From:	Caitlin Cameron
To:	Fraser, Jean
CC:	David Latulippe
Date:	7/27/2015 2:00 PM
Subject:	20 Marginal Way - condition of approval iii

I am confirming that for 20 Marginal Way, Condition of Approval iii. regarding the glazing has been met with the following agreement:

AE202

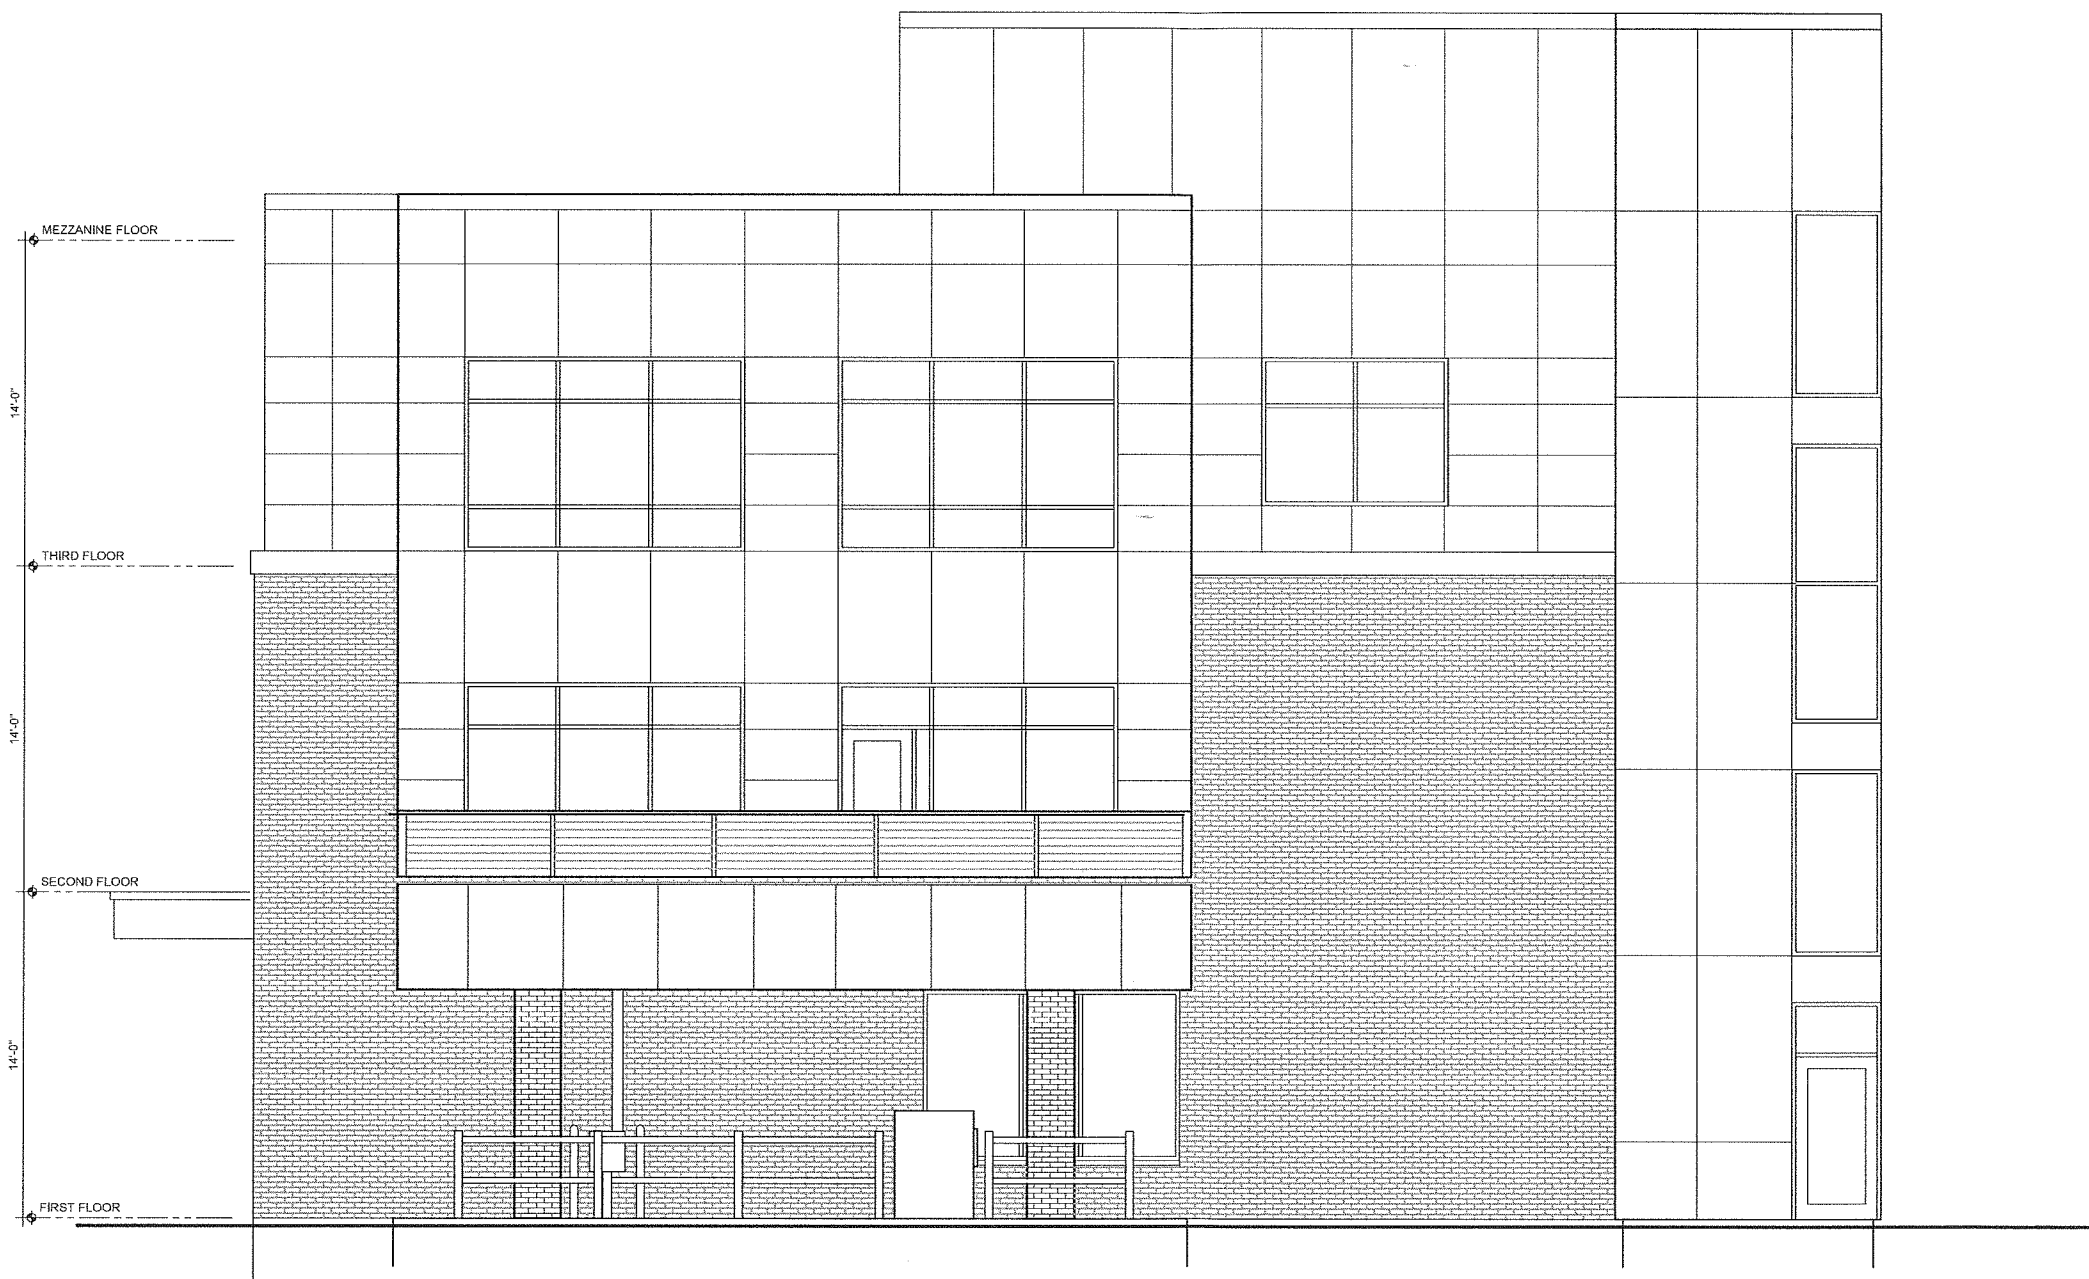
- Building elevations remain the same

- Glazing for entire building shall be Solexia + Solarban 60 with a VT of .61 and which has a slight green tint. The lower Visible Transmittance and slight green tint are allowed as a compromise for better energy performance in the building and with the understanding that interior shades will not be used.

- Spandrel glass shall be used on the transom section of storefront on the first floor only (as shown in the elevations) to mask the floor plate behind.
